Rezoning Transportation Analysis

Petition Number: 2020-080

General Location Identifier: Tax ID 12110110

Date	Description
07-23-2020	First Review (KP)

RZ1.0

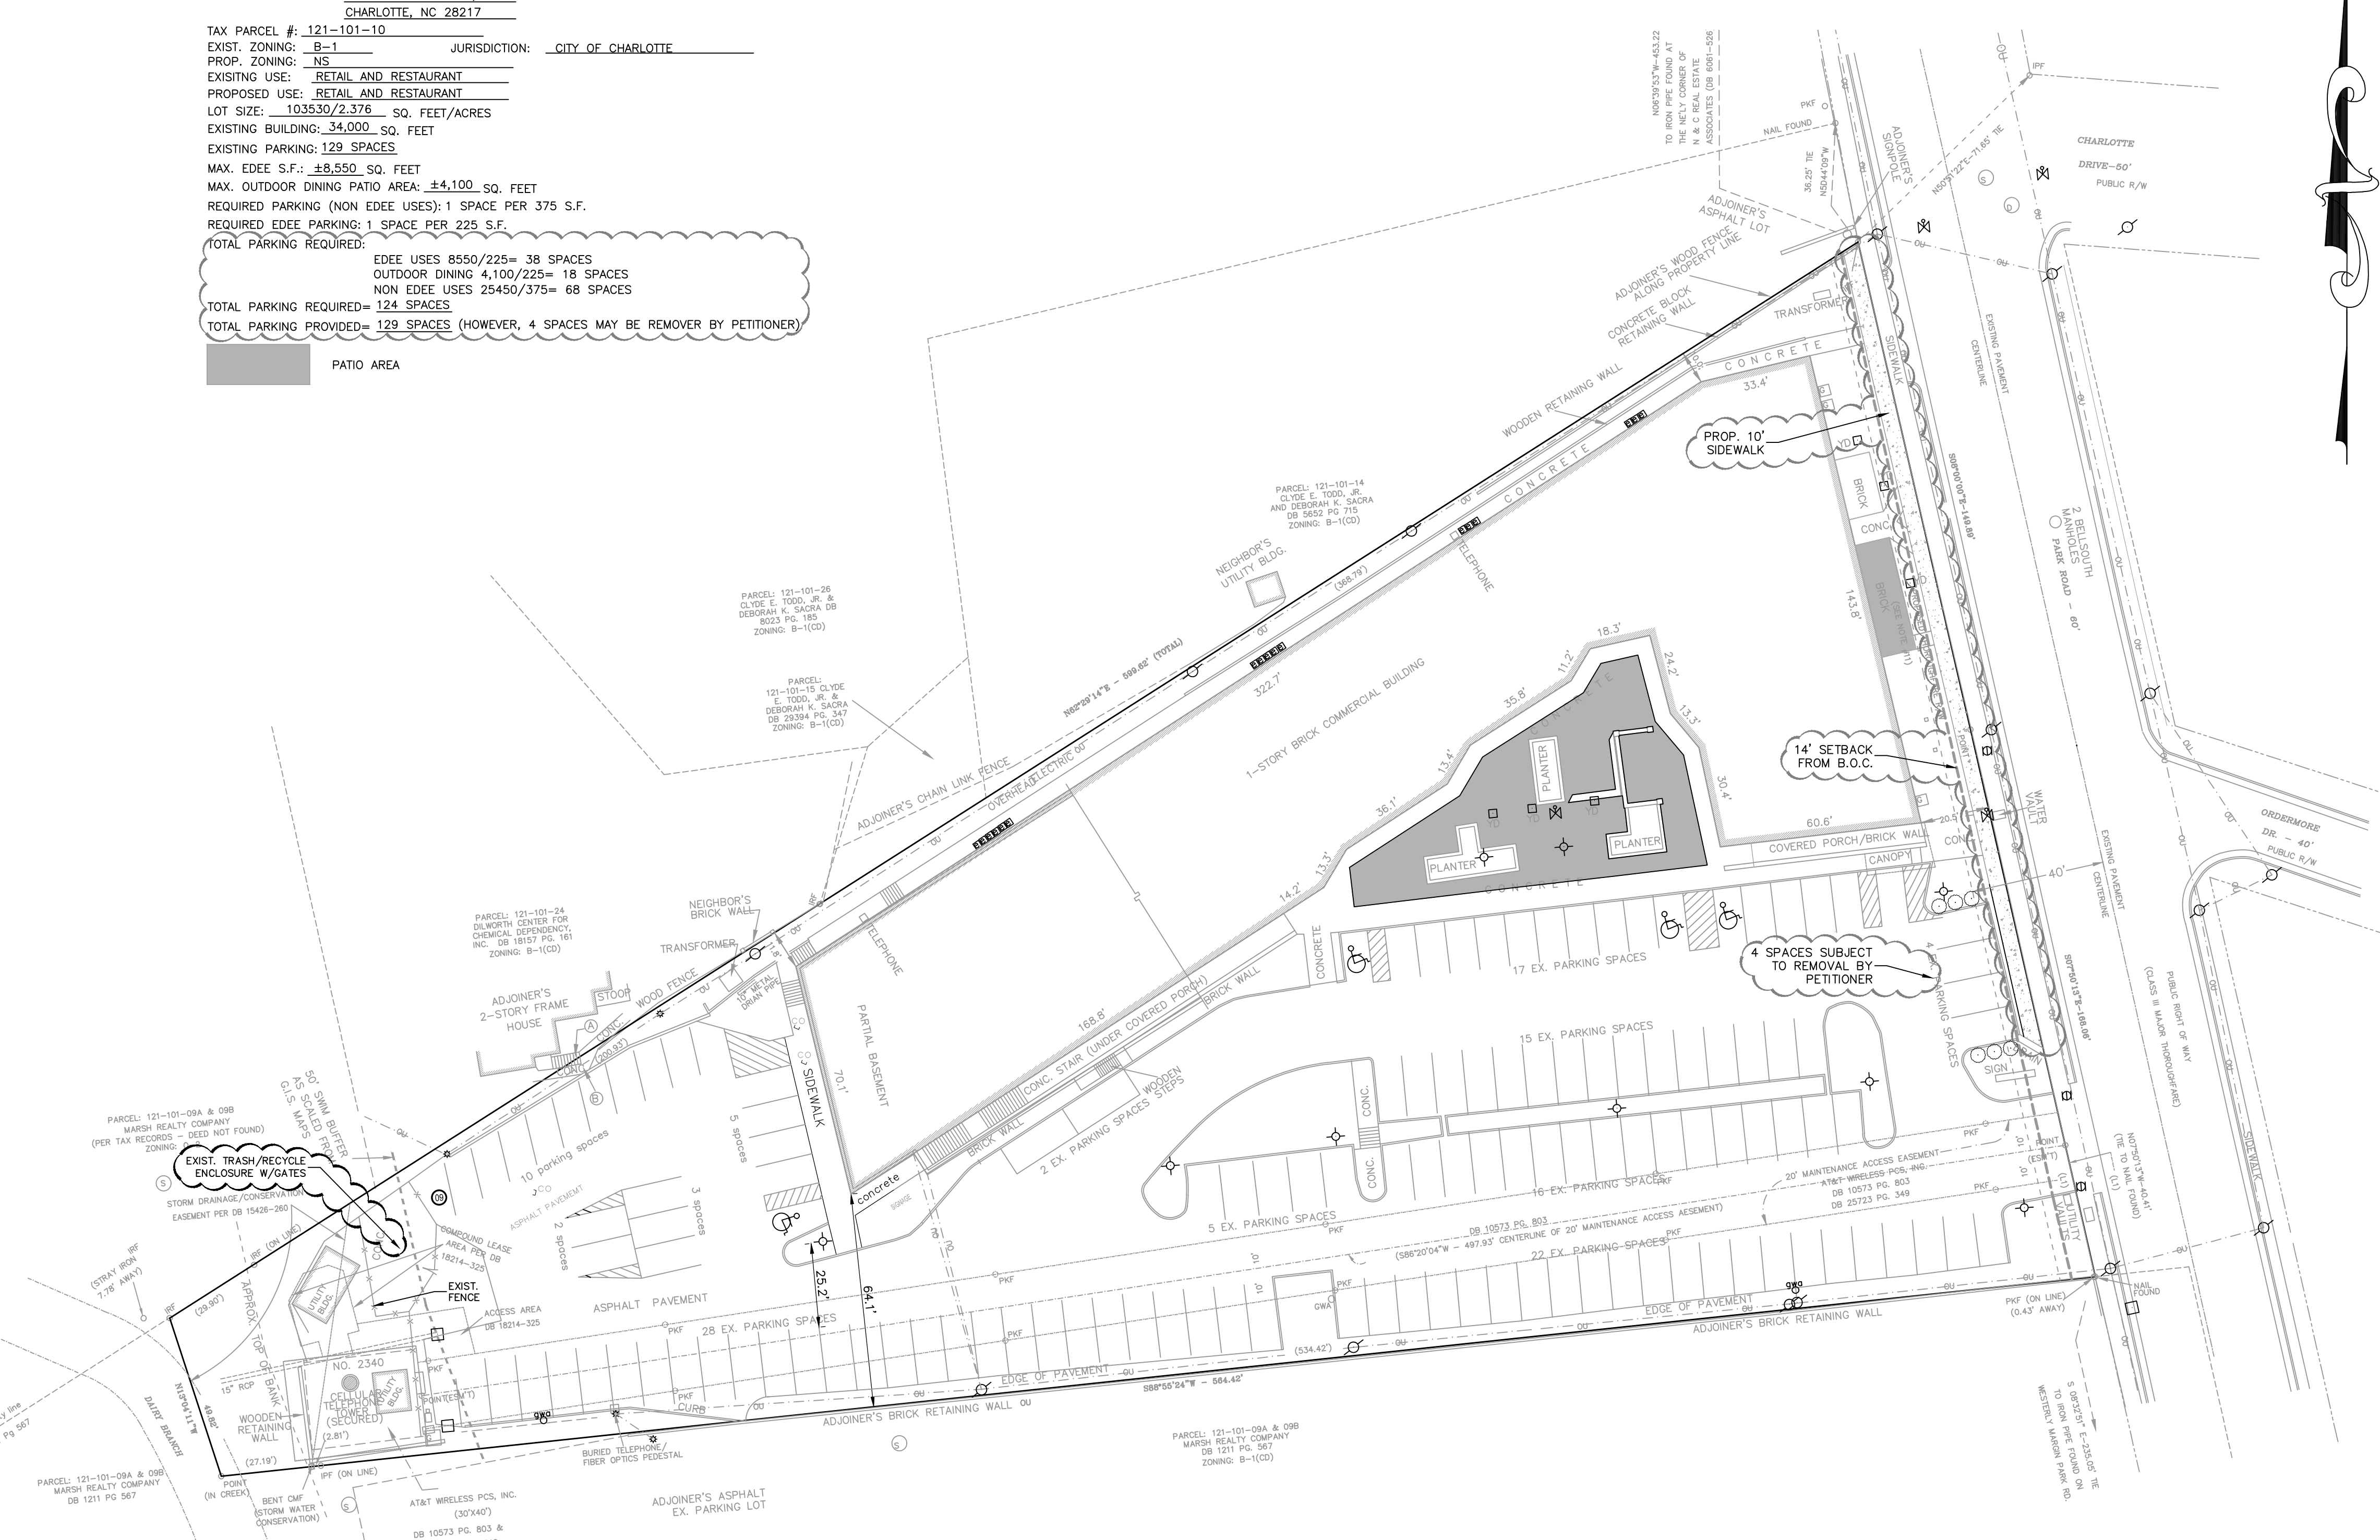
1. **Curblines** The site plan should show the curb and gutter labeled and dimensioned from the centerline for each road.
2. **Traffic Study** A Traffic Impact Study is necessary for the complete review of this petition due to the site's generation of more than 2500 daily trips.

3. The petitioner should revise the site plan and conditional note(s) to commit to construct an 8-foot planting strip, and 8-foot sidewalk on Park Road in conformance with the Dilworth Land Use and Streetscape Plan. The site plan should label and dimension both items from the back of curb and gutter and road centerline.

4. The petitioner should revise the site plan to add a note specifying dedication and fee simple conveyance of all rights of way to the City before the site's first building certificate of occupancy is issued. CDOT requests right of way set at 2' behind back of sidewalk where feasible.
5. The petitioner should revise the site plan to add a note specifying all transportation improvements will be approved and constructed before the site's first building certificate of occupancy is issued. The petitioner may phase transportation improvements if said improvements and phasing are explicitly described in site plan notes.
